# **M25 junction 10/A3 Wisley interchange**

**TR010030**

## **10.1 Report on Proposed Scheme Changes**

February 2020

Inset: Sheet 24A. Scale 1:1,000

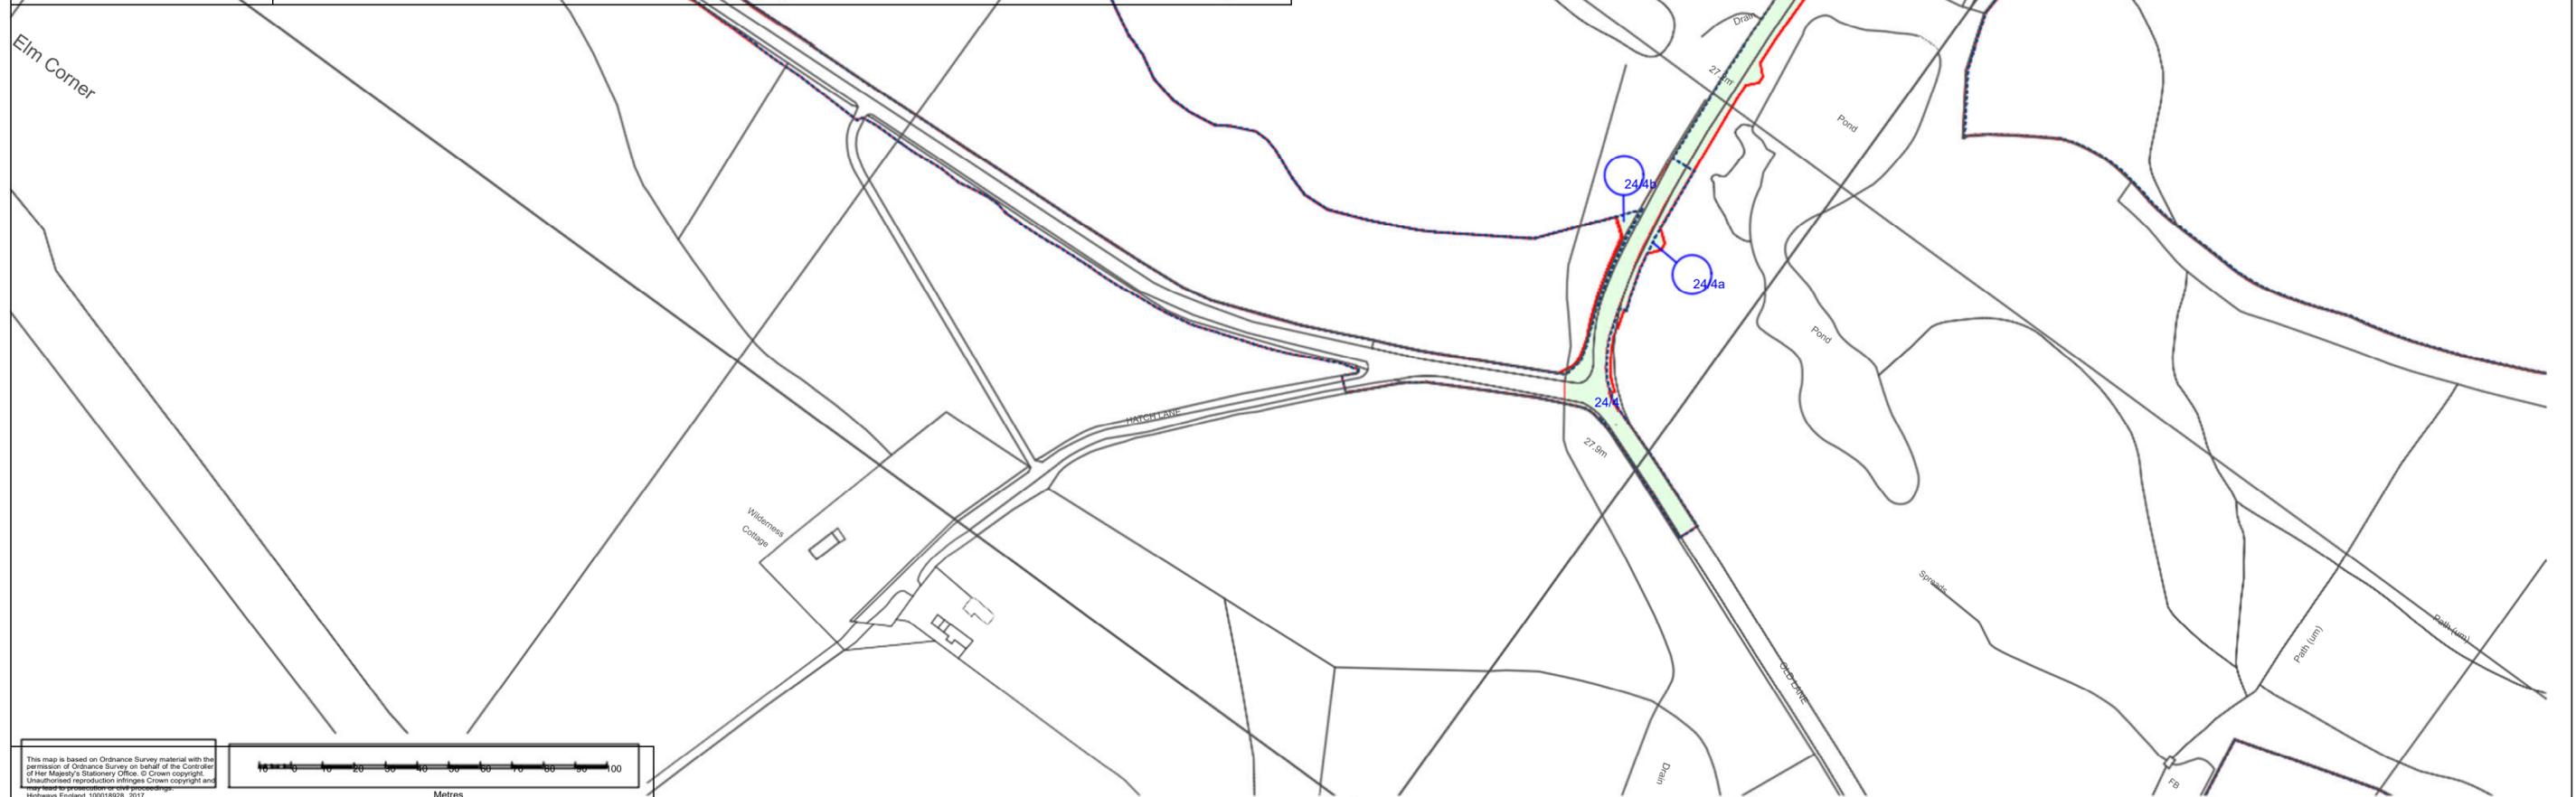
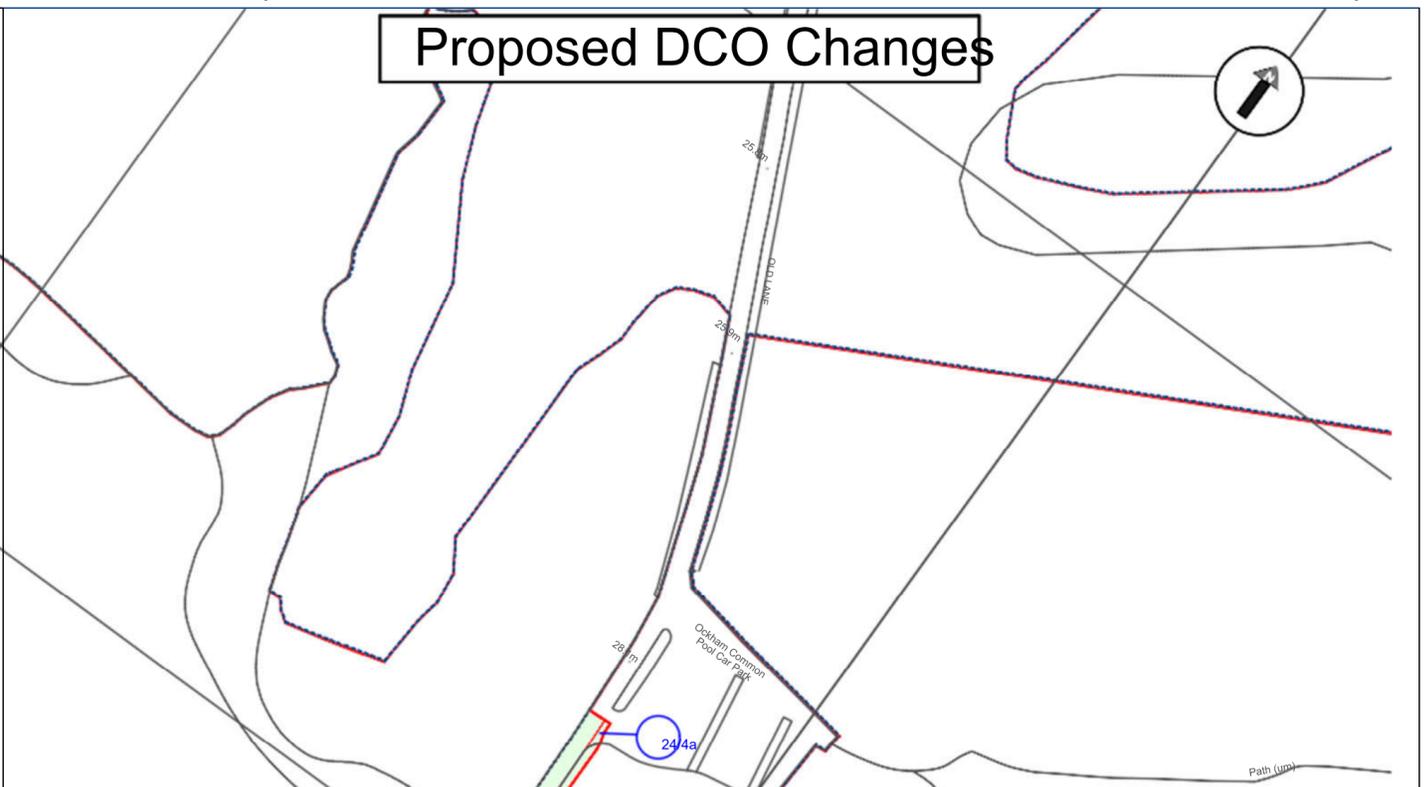
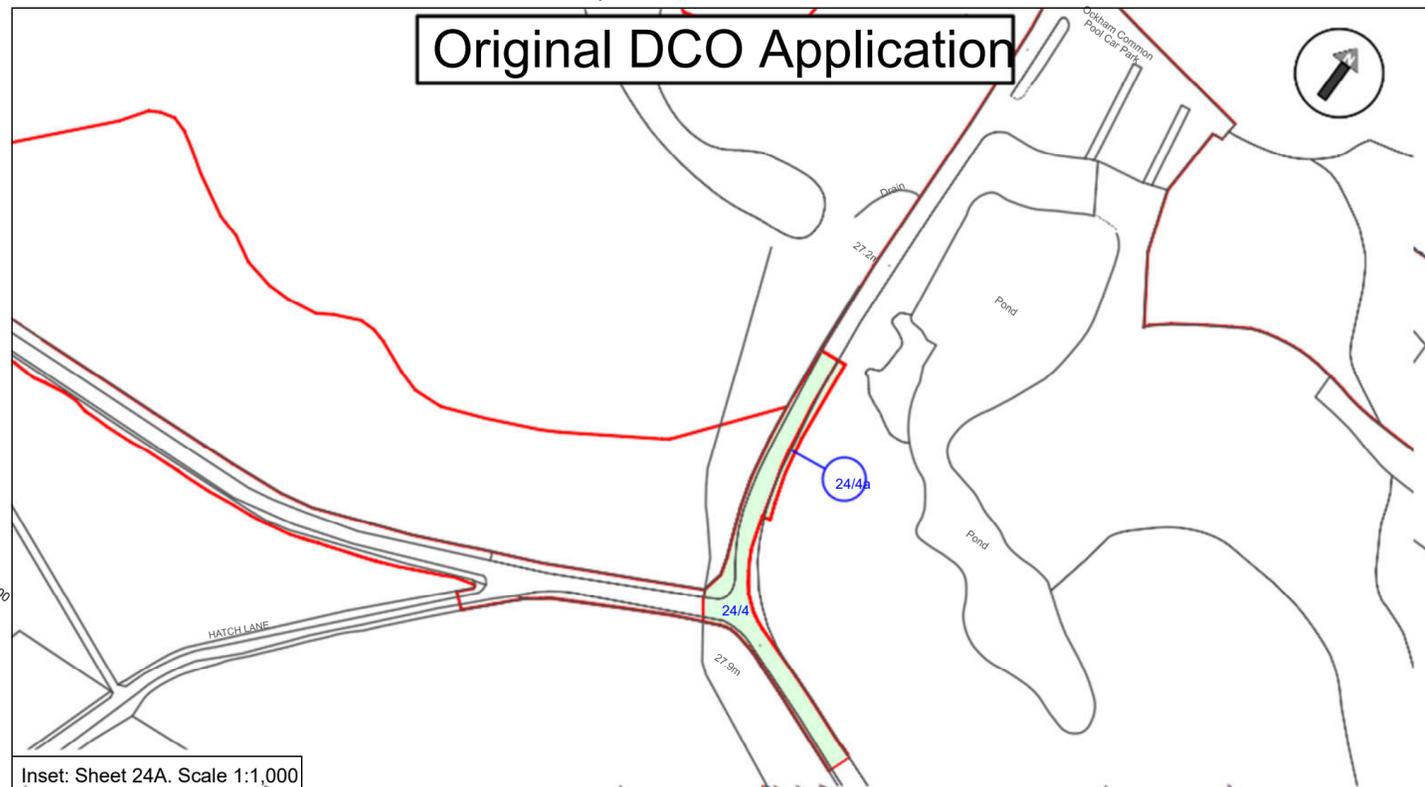
- 4.2.1 This change will result in a minor amendment to the redline boundary at Old Lane affecting Surrey County Council as landowner although only temporary possession powers will be needed to implement the change.
